DRB CASE NO/PROJECT NO: 1006726

Site Plan for Building Permit – Amended

2. **Project# 1006726**
07DRB-70173 MAJOR – AMENDED SDP FOR BUILDING PERMIT

BRAD KILLMAN AND/OR MAX KILLMAN agent(s) for ALLSTAR MOVING & STORAGE INC A NEW MEXICO CORP request(s) the above action(s) for all or a portion of Lot(s) 31, Tract(s) D-1, **RICHFIELD PARK**, zoned IP, located on WASHINGTON ST NE BETWEEN ALAMEDA NE AND PASEO DEL NORTE NE containing approximately 0.89 acre(s). (C-17)

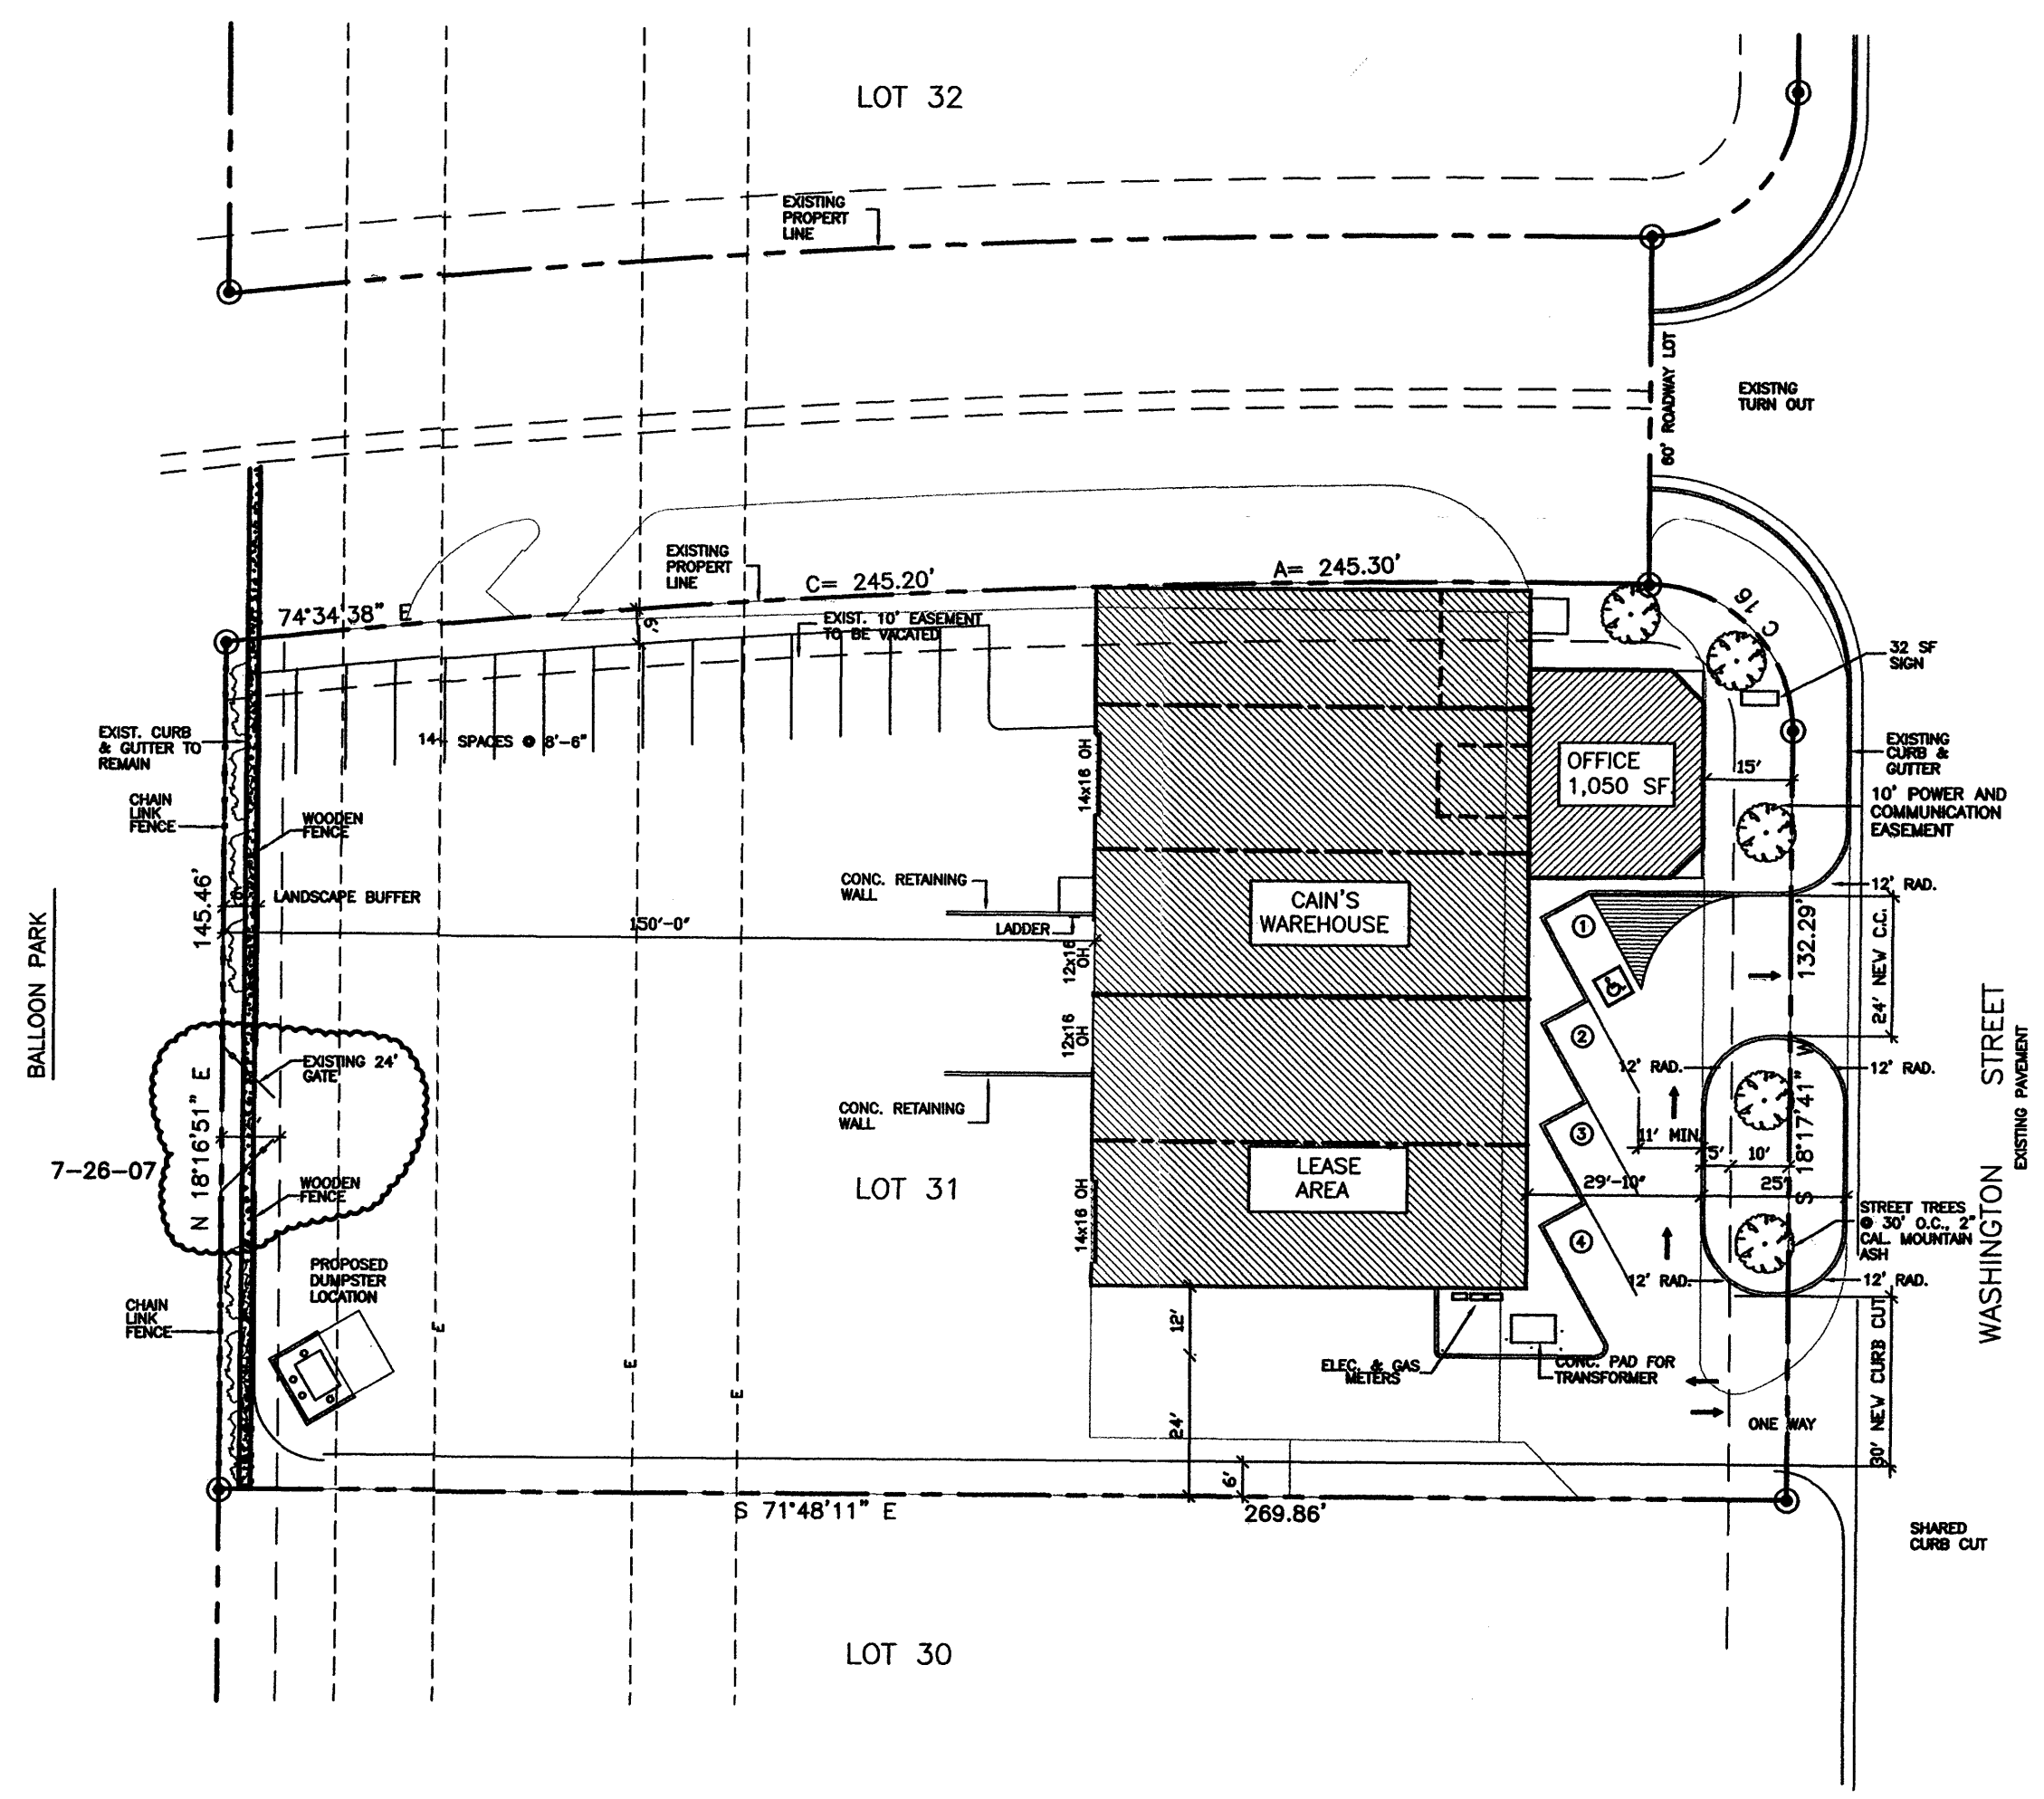
AMAFCA	No adverse comments.
COG	No comments received.
Transit	No comments received.
Zoning Enforcement	The gate should be opaque so that the screening is maintained when the gate is closed.
Neighborhood Coordination	Letter(s) sent to Wildflower Area NA (R)
APS	Richfield Park , Lots 31, Tract D-1, located on Washington St NE between Alameda NE and Paseo del Norte NE, requests a building permit for a gate that will provide access to Balloon Museum Dr NE. This request will have no adverse impacts on the APS district.
Police Department	No crime prevention or CPTED comments at this time.
Fire Department	No adverse comments.
PNM Electric & Gas	No adverse comments.
Comcast	No comments received.
QWEST	No comments received.
Environmental Health	No comments received.
M.R.G.C.D.	No adverse comments.
Open Space Division	Open Space has no adverse comments.
City Engineer	Defer to Transportation.

Are the curb cuts on Washington being proposed? The traffic analysis requested by the City Engineer is needed to evaluate the proposed access onto Balloon Fiesta Parkway.

Parks & Recreation Label the site plan amended. Is the request to allow access off Balloon Muesum Dr.?

Planning Department The site plan needs some minor corrections in the title and signature block:

- The title should read "Site Plan Amended"
 - "Approval of Existing Gate Only"
 - "DRB Case Number"
 - DRB Application Number"
 - The signature for the City Planner should read "DRB Chairperson"
 - The signature line for New Mexico Utilities should be removed.
- The vicinity map is missing.

Planning defers to Transportation on the gate issue.
